RESPONSE TO REQUESTS FOR INFORMATION (RFI)

**Proposed Waste Management facility (SSD-62855708)
2-4 Hale Street, Botany**

Reference: 23.464r07v05
Date: September 2025

APPENDIX 1 – Swept Path Analysis Diagrams

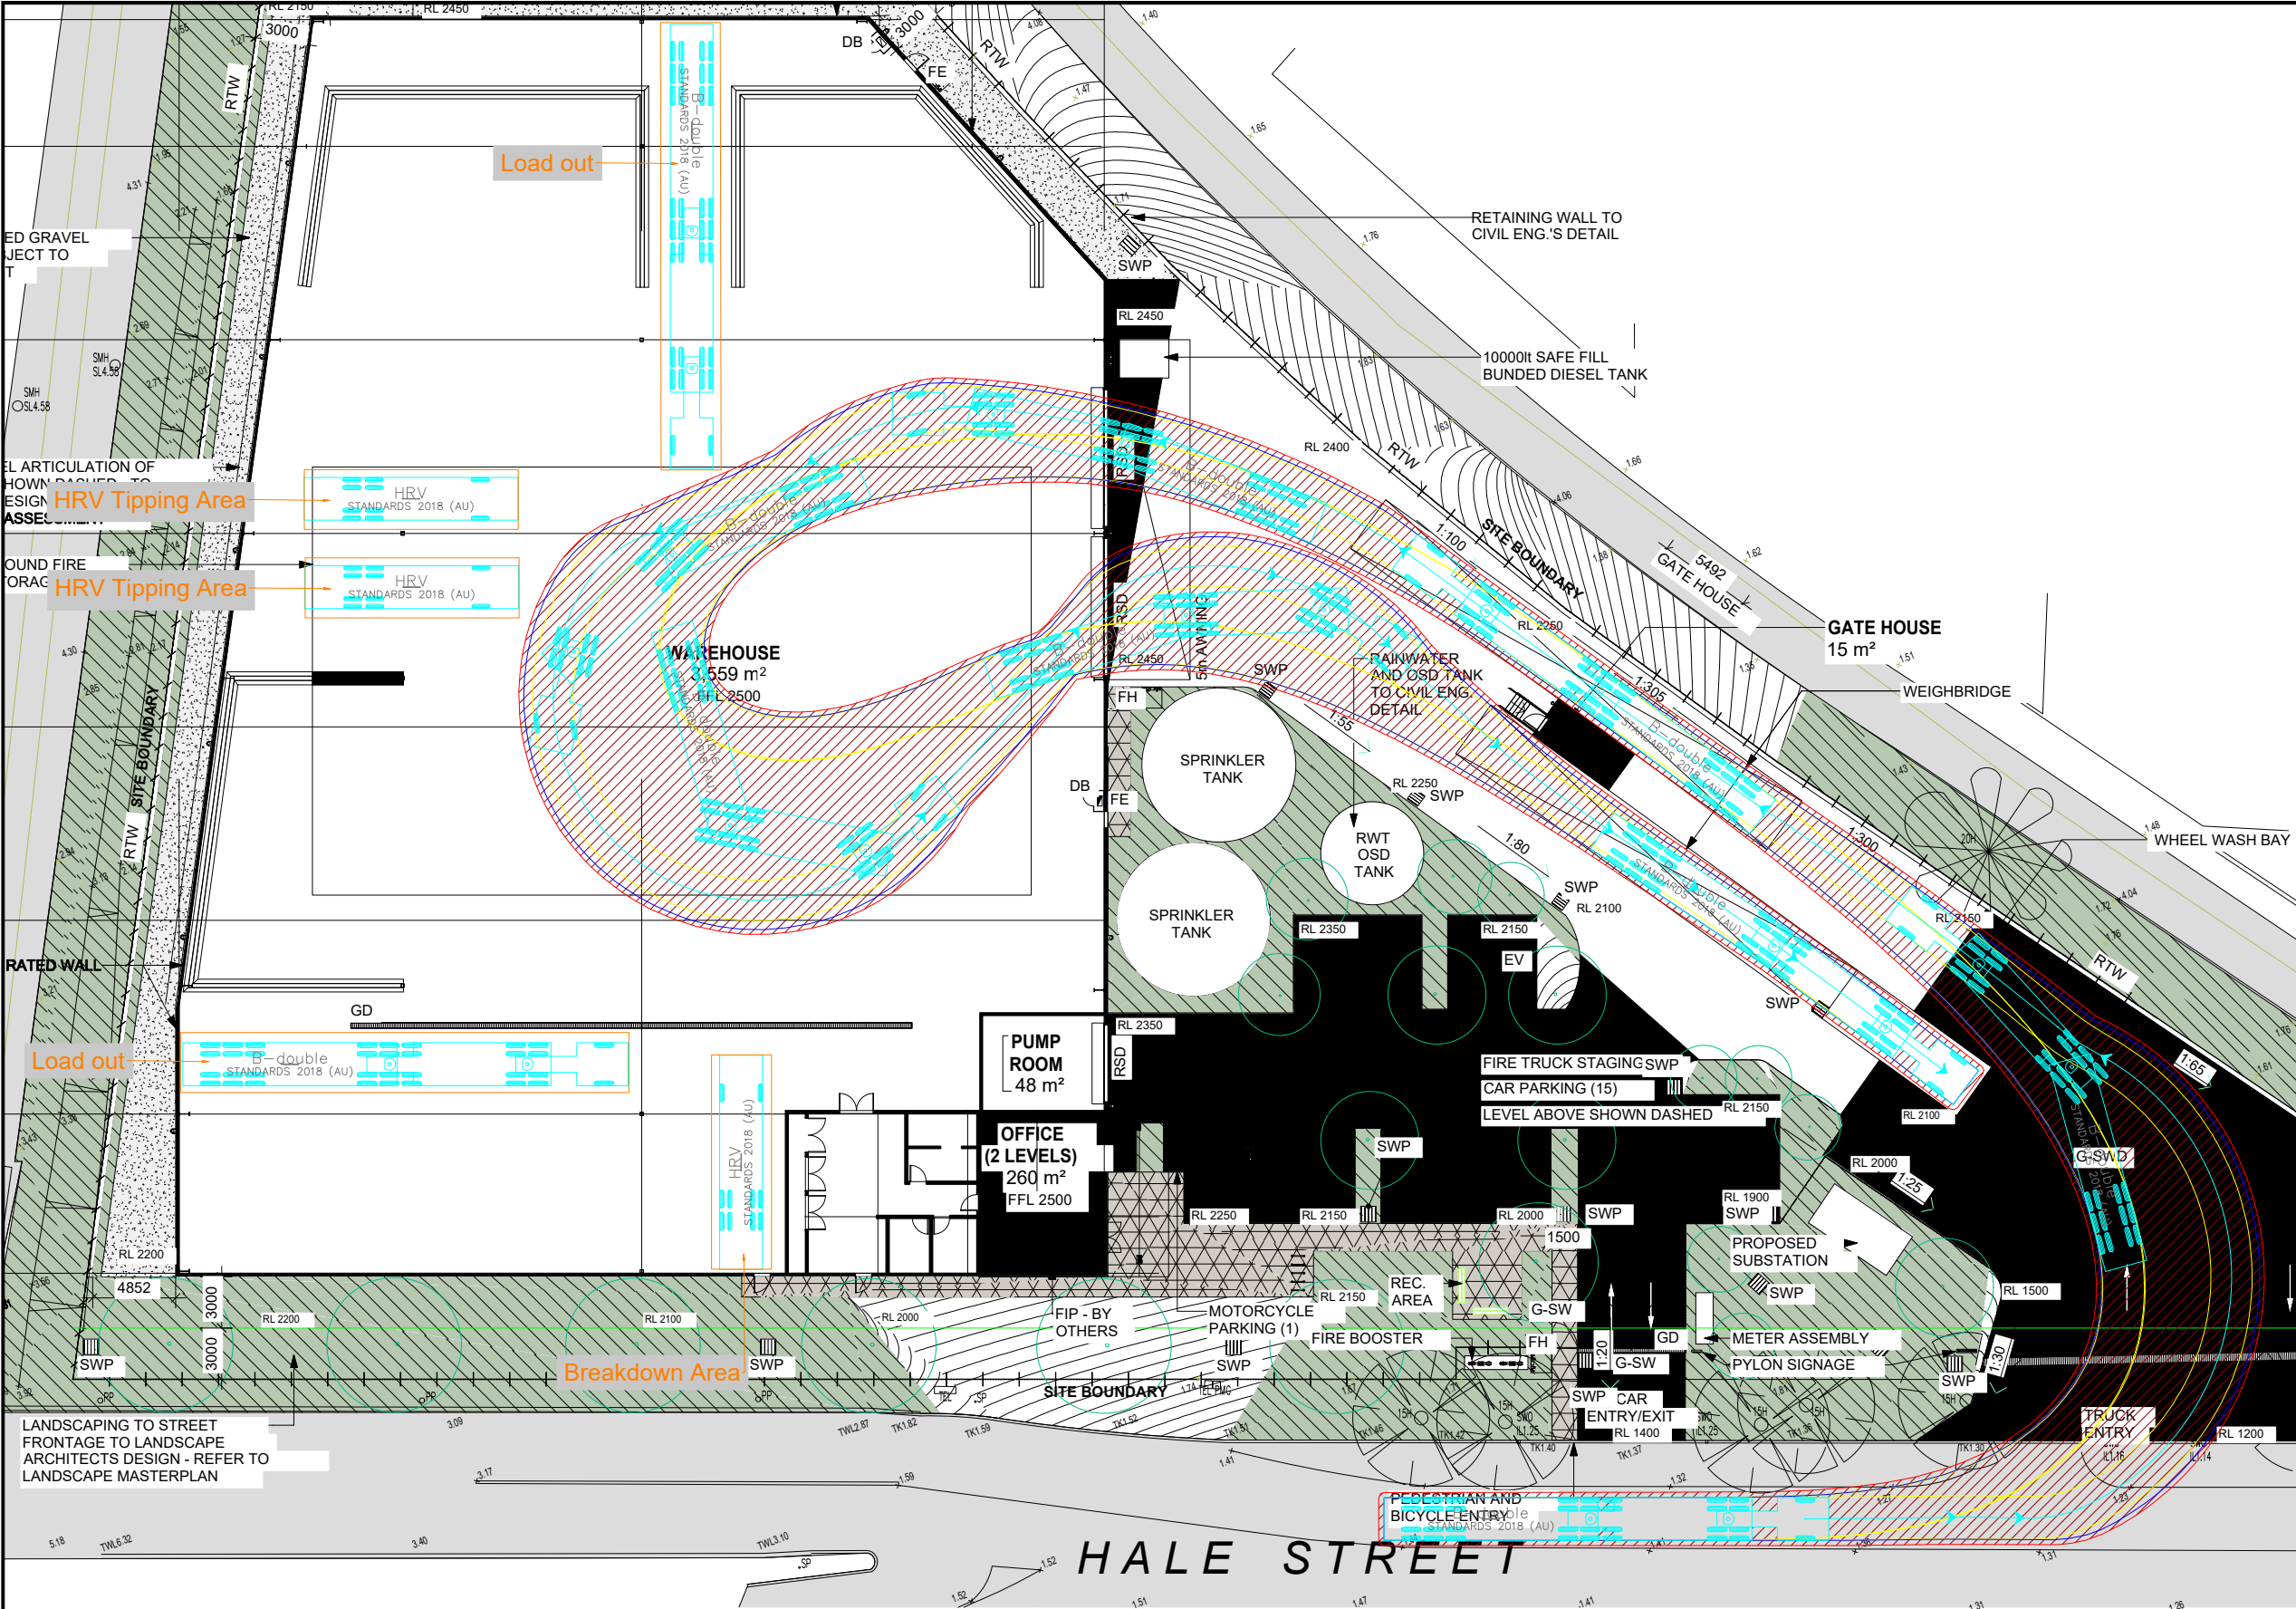
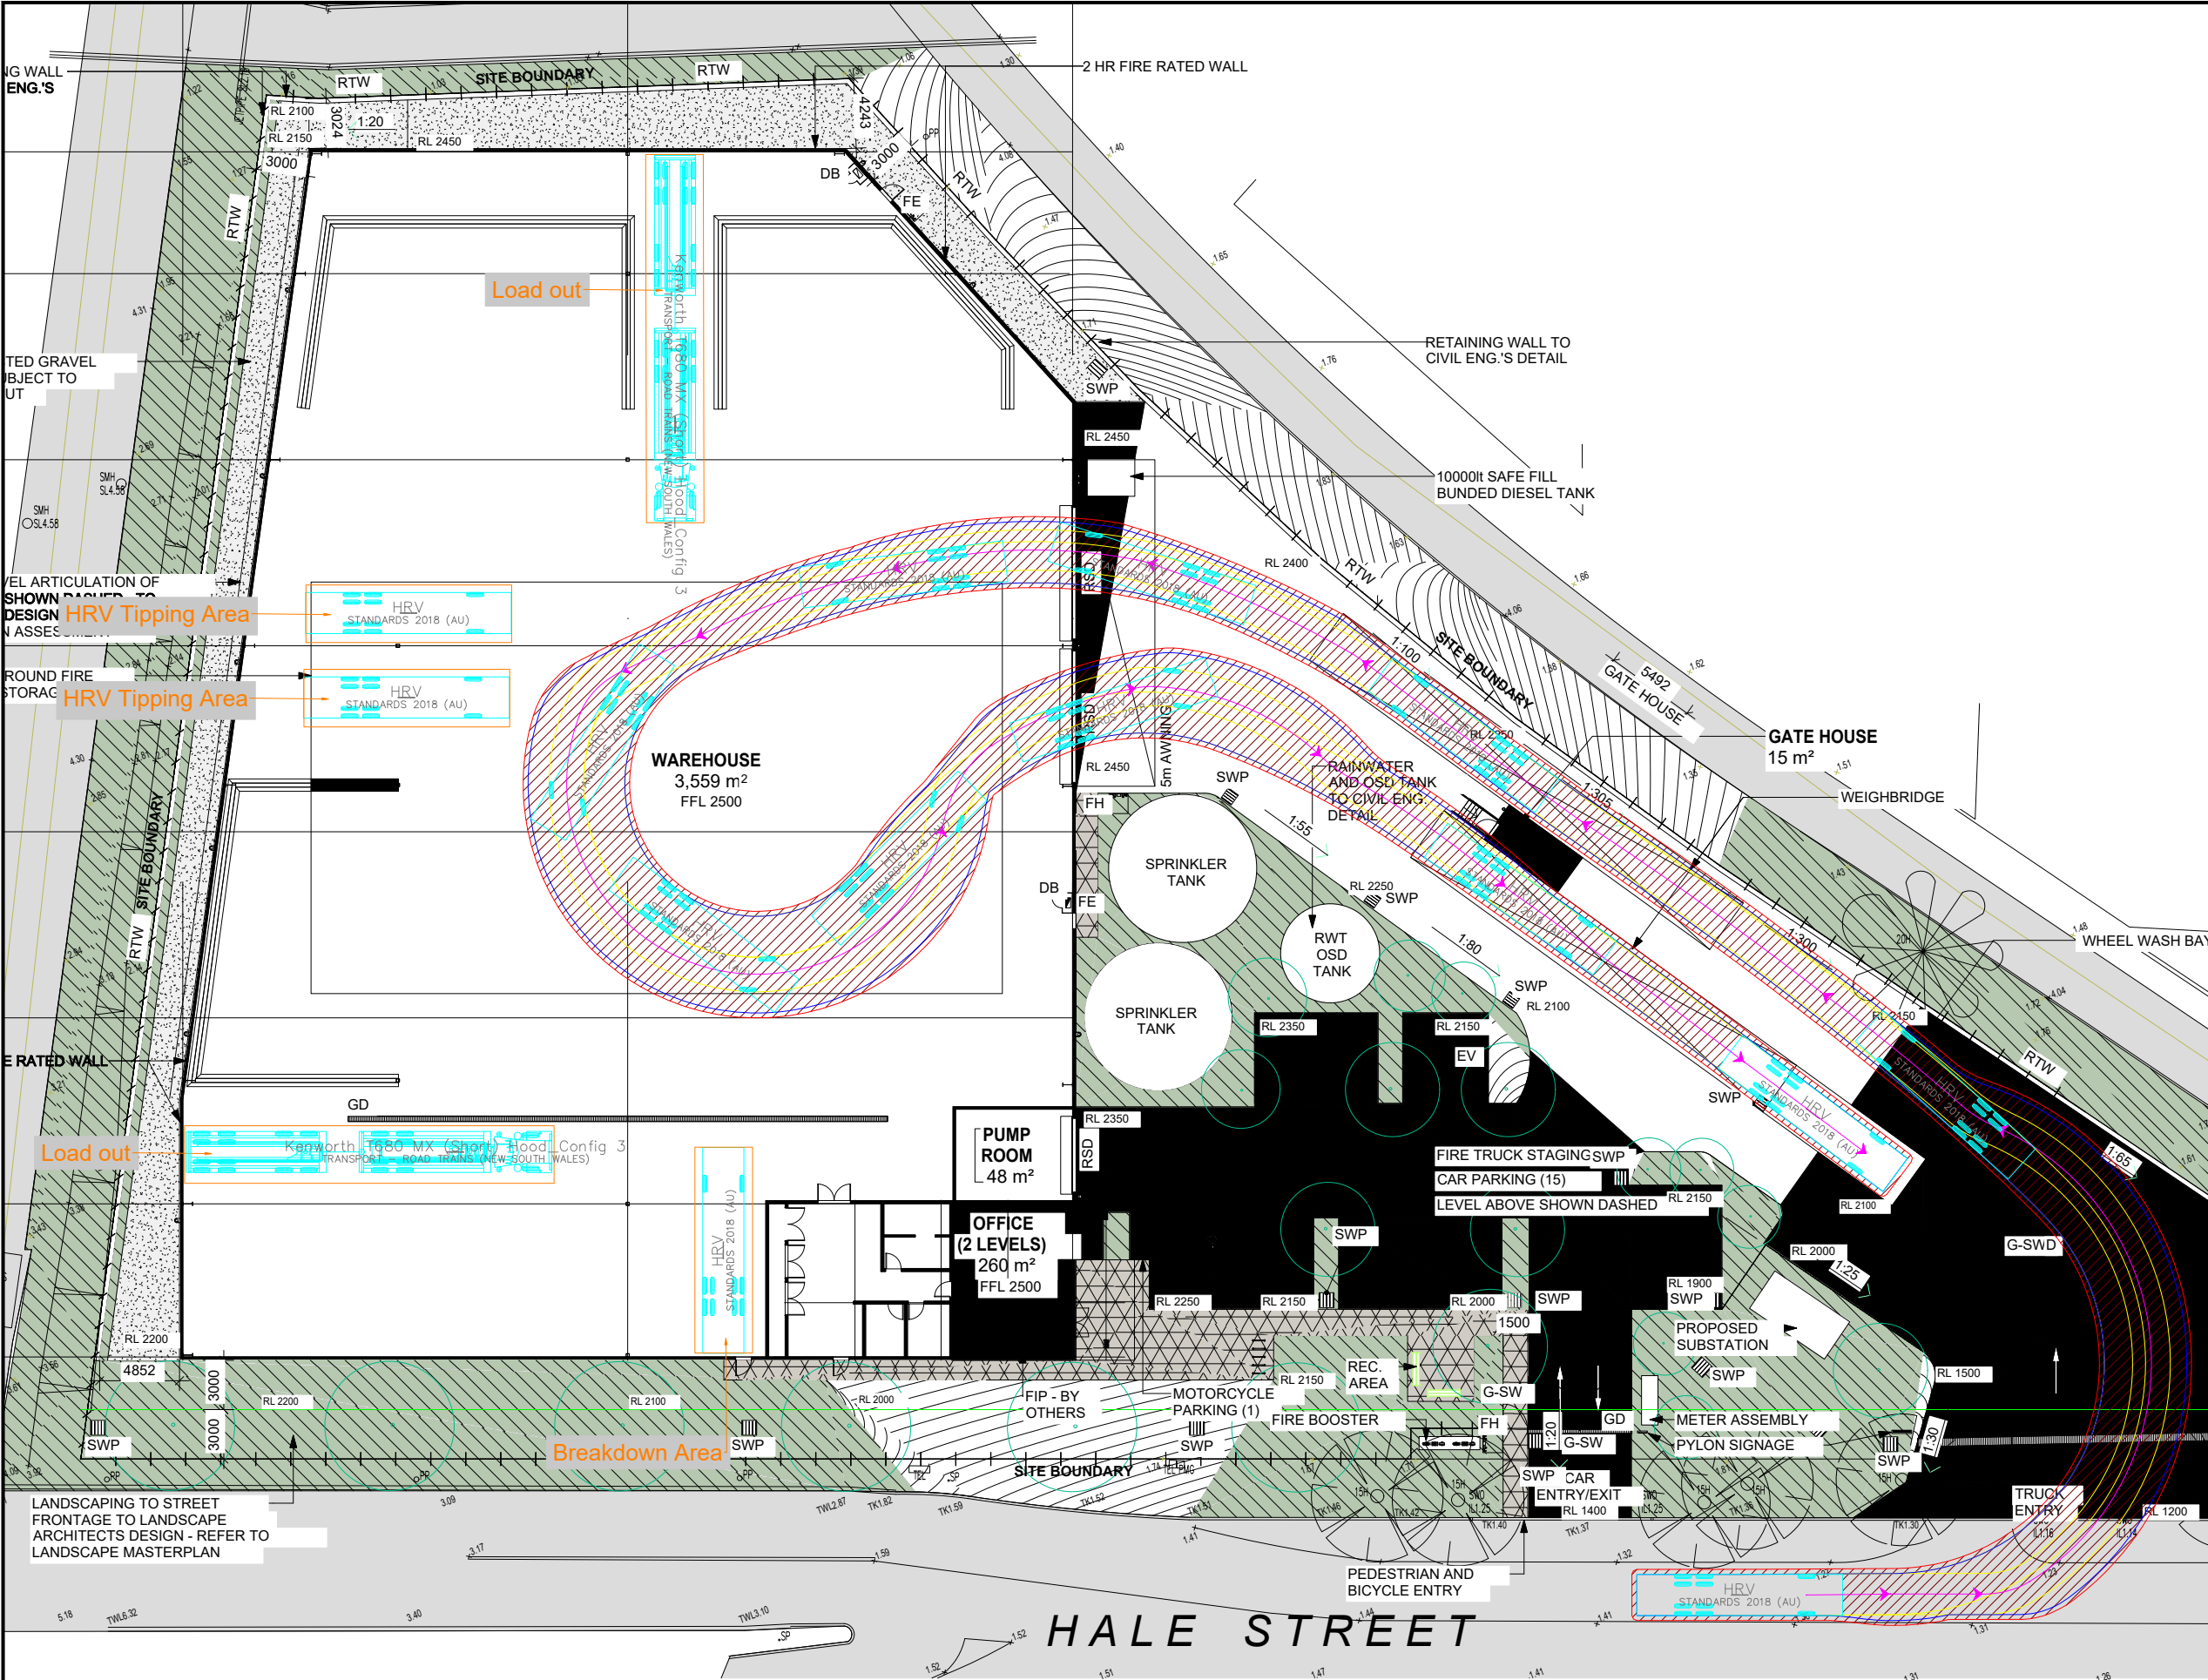
The swept path analysis shows the movement of a B-double exiting the site on a separate drawing to the swept path of a B-double accessing the site. It is not possible to determine if there will be any conflicts if these two movements occur simultaneously. Please provide a plan that shows a B- double entering and exiting the site simultaneously demonstrating that this movement can occur safely and without any conflict to either vehicle or on-street parking, and without crossing the centreline of Hale Street.

- *“Details of how trucks collecting waste will not conflict with incoming vehicles unloading waste – to be supported by commentary and figures clearly demonstrating how this will be achieved.”*

Having considered the above, **Figure 1** below clearly demonstrates a 26m B-double vehicle will be able to satisfactorily enter the site whilst another 26m B-double vehicle is waiting to exit the site, under conservative operational assumptions.

Reference should be made to the swept path analysis provided in **Attachment 3** showing the satisfactory truck movements to / from the proposed breakdown bay. Implementation of measures as part of an operational traffic management plan is an enforcement matter is to be addressed by the operator.
